Further or Amended Plans/Information Received – revised layout, FRA rev P06, Drainage Maintenance Plan rev 04

Observations By:	KC, Lead Local Flood Authority
------------------	-----------------------------------

Consultation Response from KC, Lead Local Flood Authority
2024/93605 Land at, Main Avenue, Cowlersley, Huddersfield, HD4 5US
Erection of 57 dwellings with access from new through road connecting Main Avenue and Windsor Road, and associated works, including engineering and landscaping
Date Responded: 10th November 2025 Responding Officer: Paul Farndale Responding Ref: 3

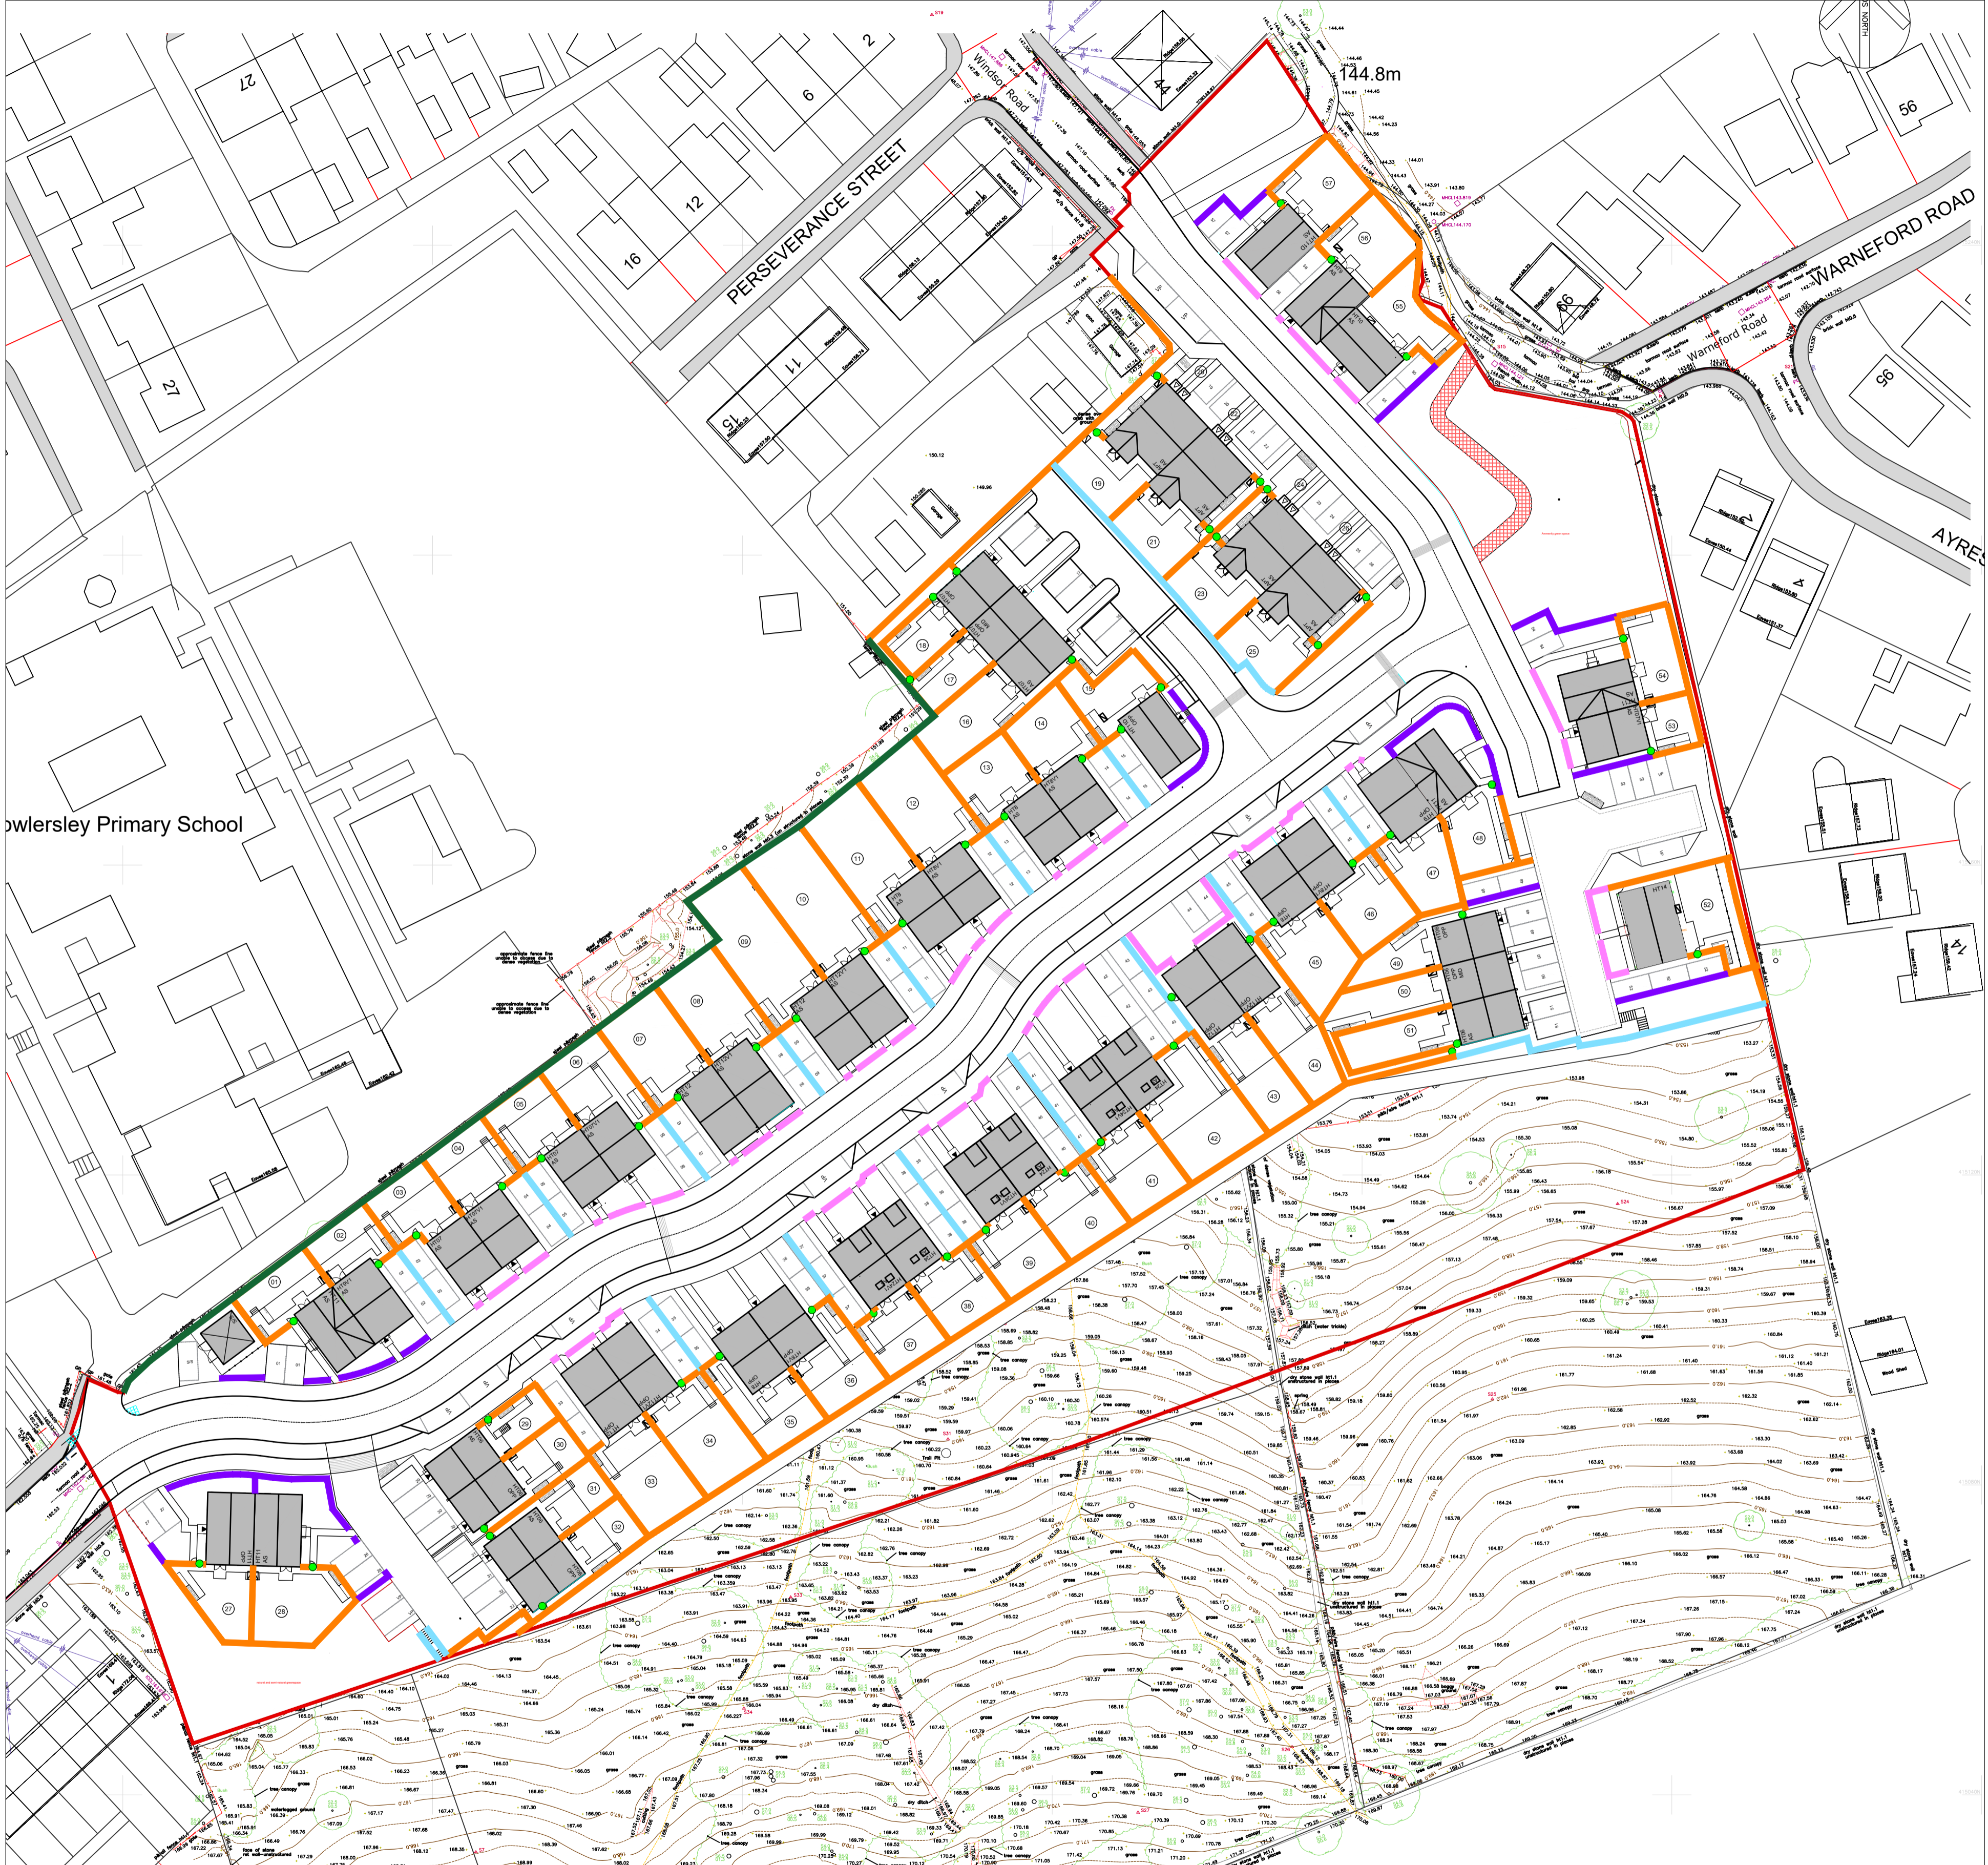
- The flood risk assessment says the southern boundary will have a parapet wall to aid flood routing. This does not appear to have been considered on boundary treatment plans that show close board fencing.
- Flood routing diagrams show levels pushing run off from open land from the south along stairs adjacent to plots 51 and 52. Many other plans show contours with the low spot low spot in the landscape away from the recommend stairs route which would result in ponding behind the retaining wall.
- Please ensure that are now planting schemes within 5m of the headwall and culverted section of watercourse.
